STATE OF NORTH CAROLINA
DEPARTMENT OF TRANSPORTATION

Addendum No. 1

RE: Contract # C204719

I-40 FROM EAST OF SR-1007 (1ST ST WEST) TO EAST OF NC-115

BEULAH RD
 OFFSITE DETOUR

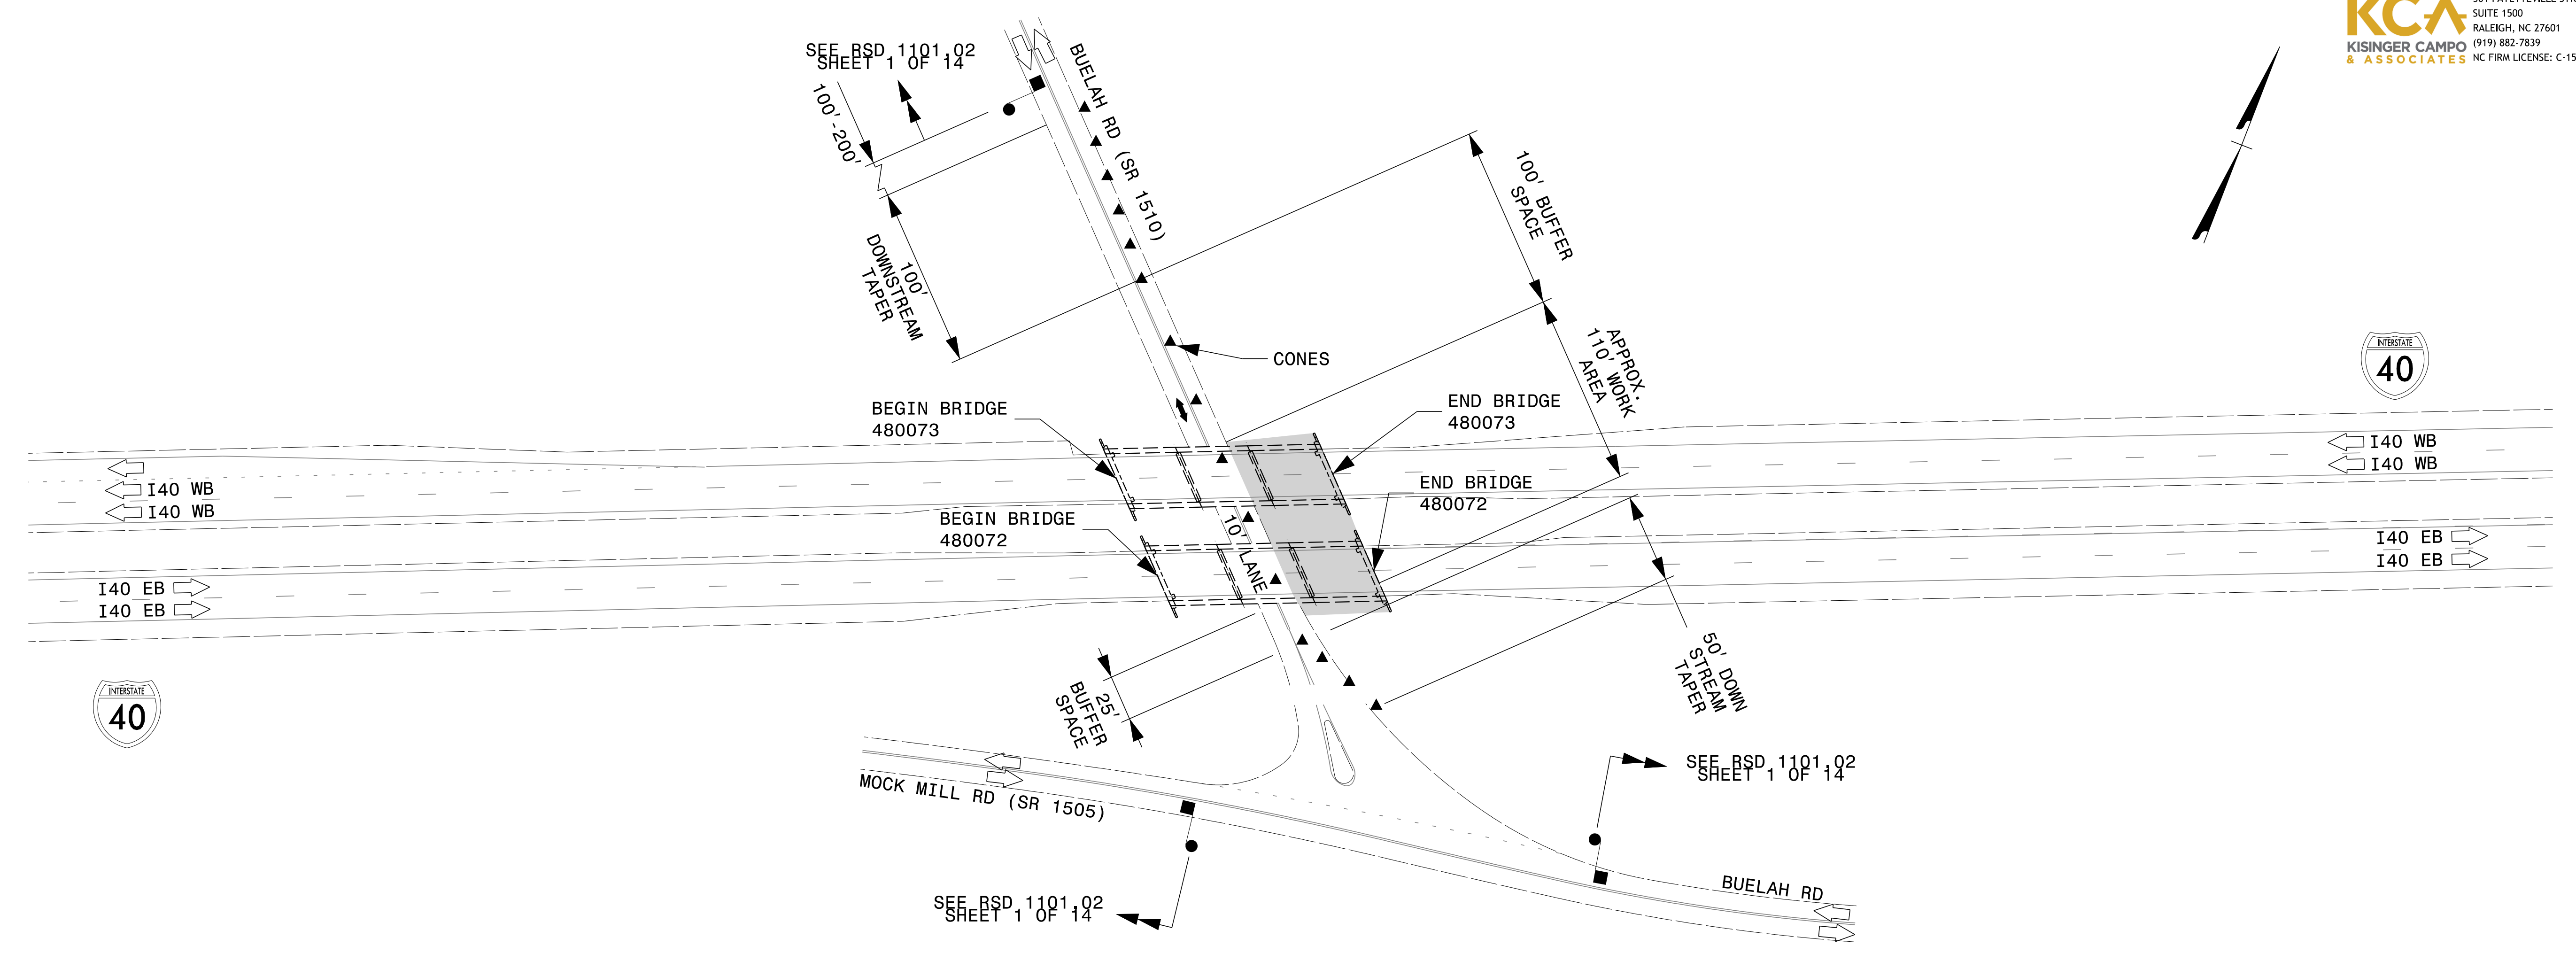
Sheet No.	Revision
TMP-1A	Addition of sheets TMP-36A and TMP-36B to Index of Sheets
TMP-1C	Time Restrictions revised Addition of Beulah Rd to Lane Closure Time Restrictions Note added to Road Closure Time Restrictions for Closure of Beulah Rd
TMP-1E	Revised Phasing for Beulah Rd, from closure to flagging operation
TMP-1F	Revised Phasing for Beulah Rd, from closure to flagging operation Note added to Phasing
TMP-1G	Revised Phasing for Beulah Rd, from closure to flagging operation
TMP-10	Removed note for task lighting
TMP-11	Removed note for task lighting
TMP-29	Removed note for task lighting
TMP-30	Removed note for task lighting
TMP-36	Added note concerning closure of Beulah Rd
New TMP-36A	Addition of TMP Sheet for the flagging operation on Beulah Rd (NB lane closure)

**SR 1510 (BEULAH RD)
 SOUTHBOUND
 LANE CLOSURE
 DETAILS**

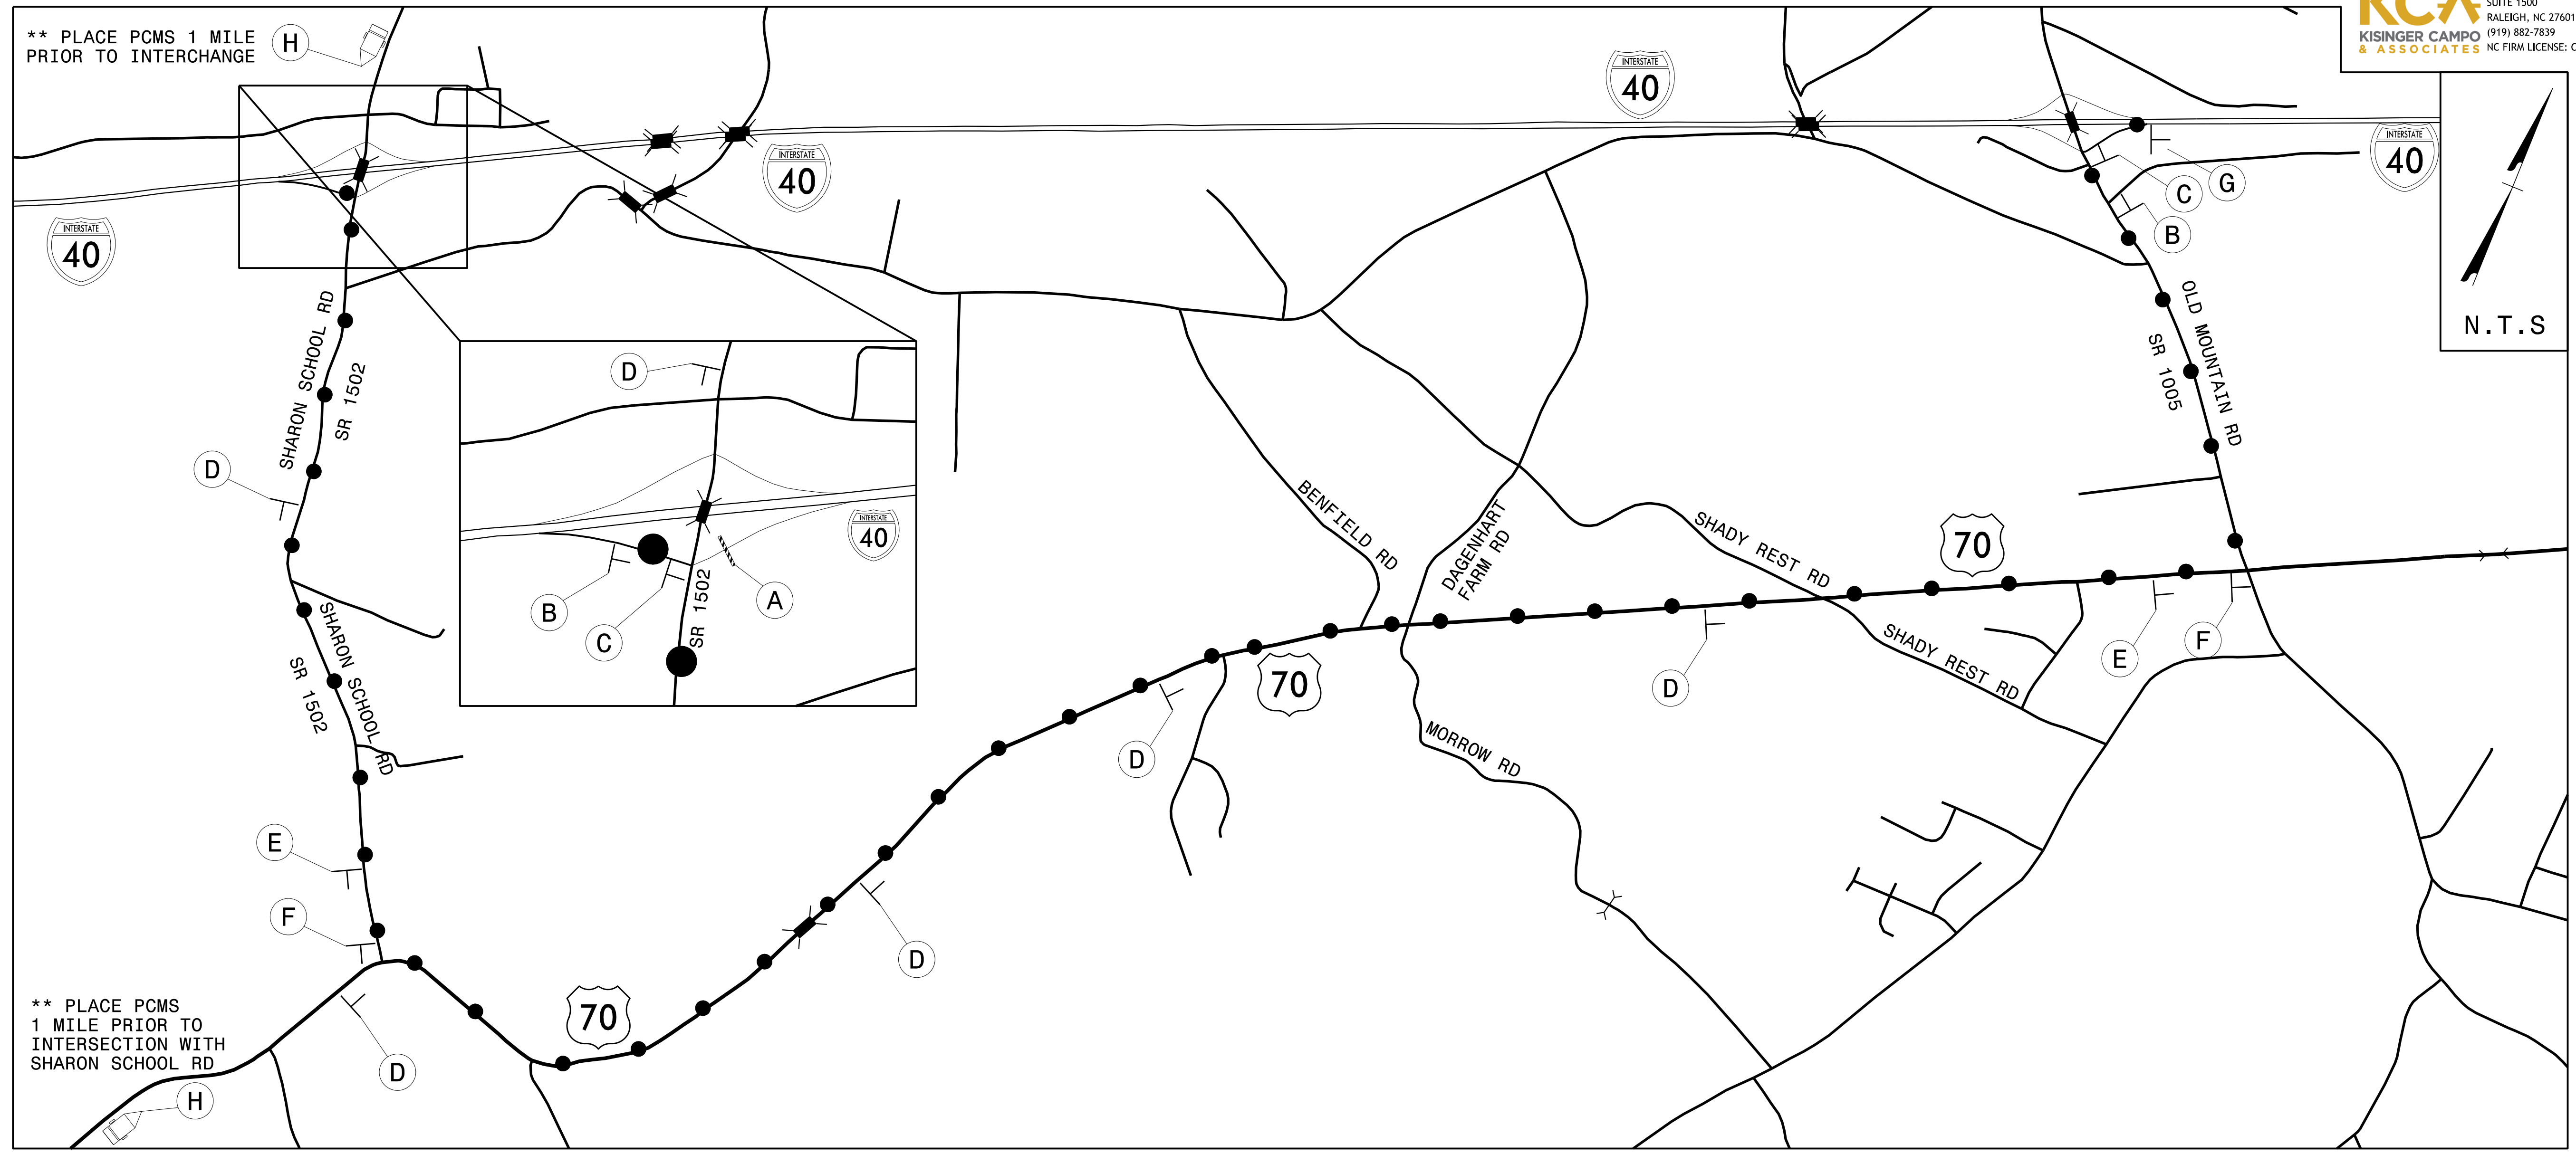
Sheet No.	Revision
New TMP-36B	Addition of TMP Sheet for the flagging operation on Beulah Rd (SB lane closure)
